From: Greenwood, Suz K <[REDACTED]>
Sent: 08 May 2019 09:59
To: Simon Davis <Simon.Davis@arun.gov.uk>
Subject: FW: AL/27/19/DOC - GTR DENMANS LANE FONTWELL

I am chasing a consultation response on AL/27/19/DOC which seeks the discharge of condition 08 *"Piling or any other foundation designs using penetrative methods shall not be permitted other than with the express written consent of the Local Planning Authority, which will only be given for those parts of the site where it has been demonstrated that there is no resultant unacceptable risk to controlled waters."*

FOUNDATION NOTES :-

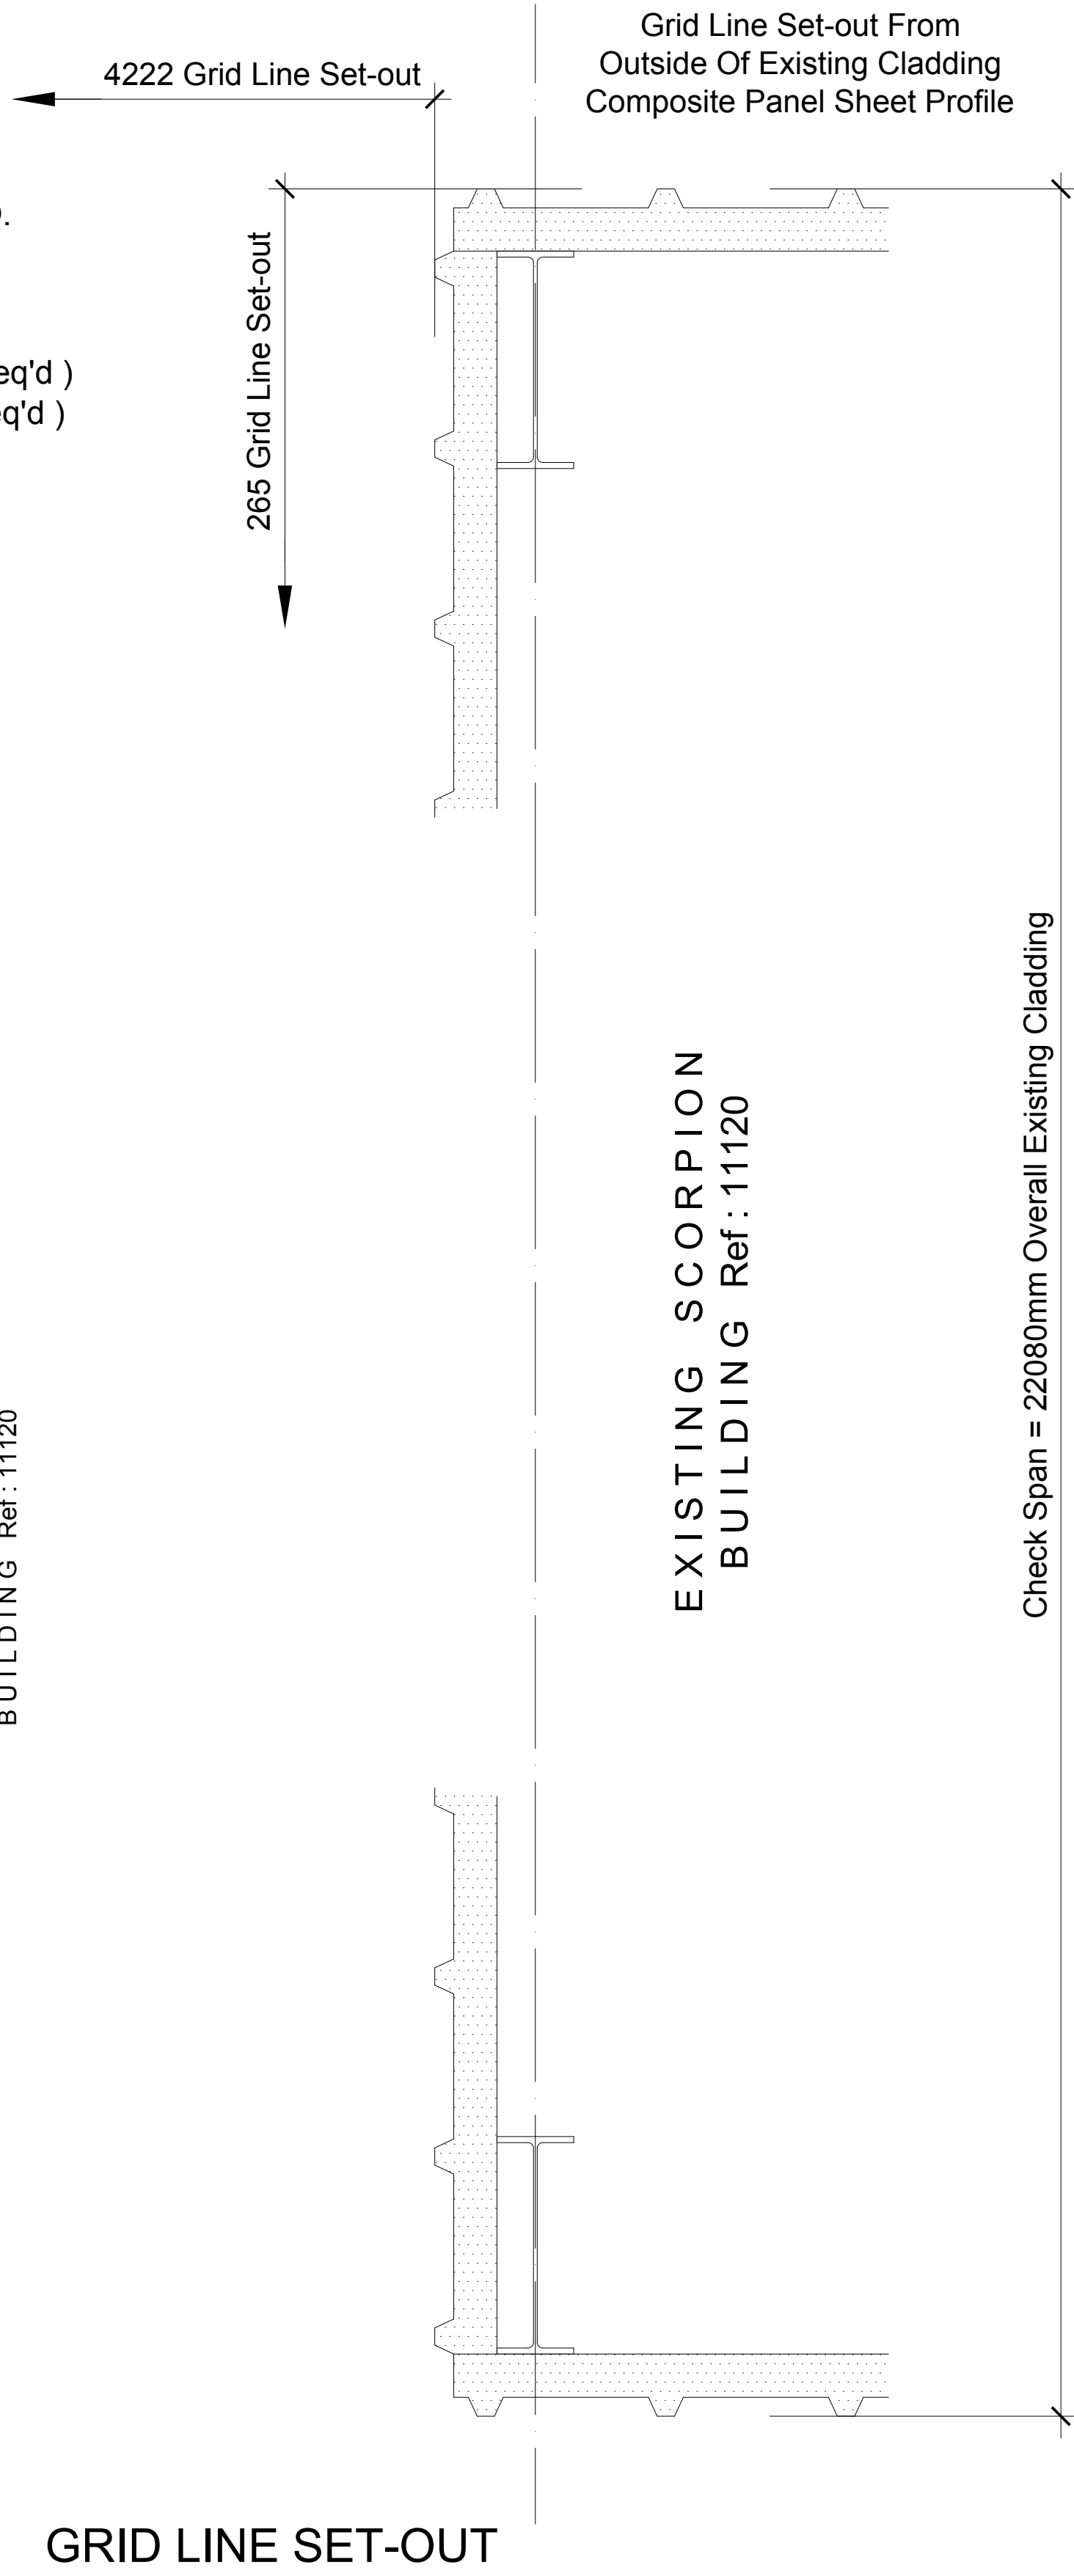
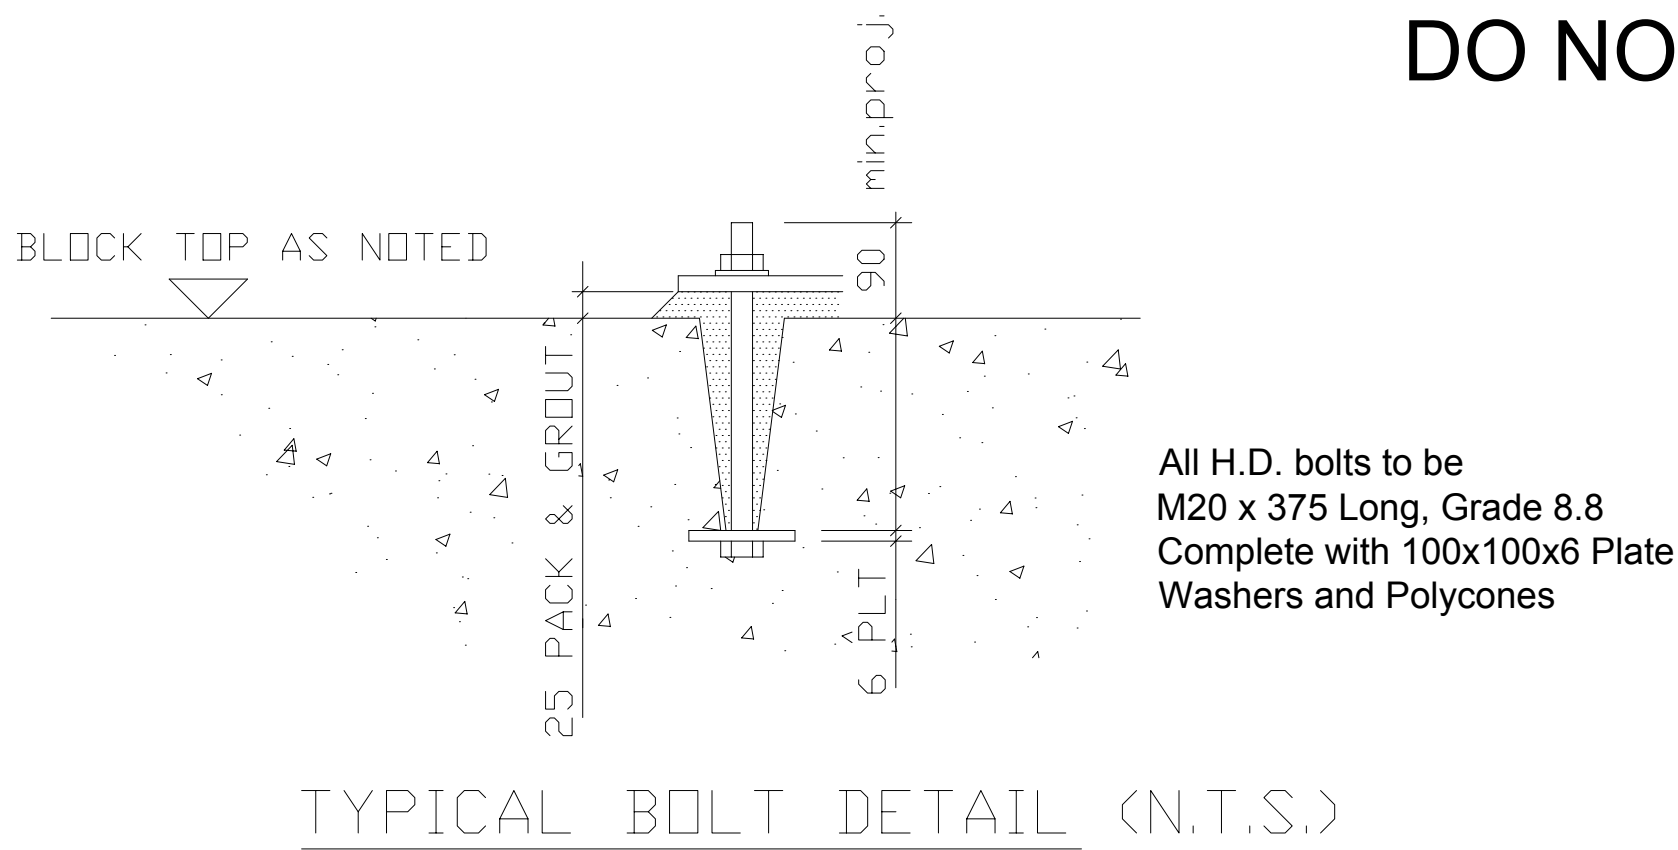
The application states that although piling is not used they will be using concrete blocks to a max depth of 1.75m. Having discussed with Building Control officers here, I consider that this is a penetrative method hence the need to gain approval. Can you therefore advise whether you are in agreement with this? There are additional details of the foundations in the plans available on our website
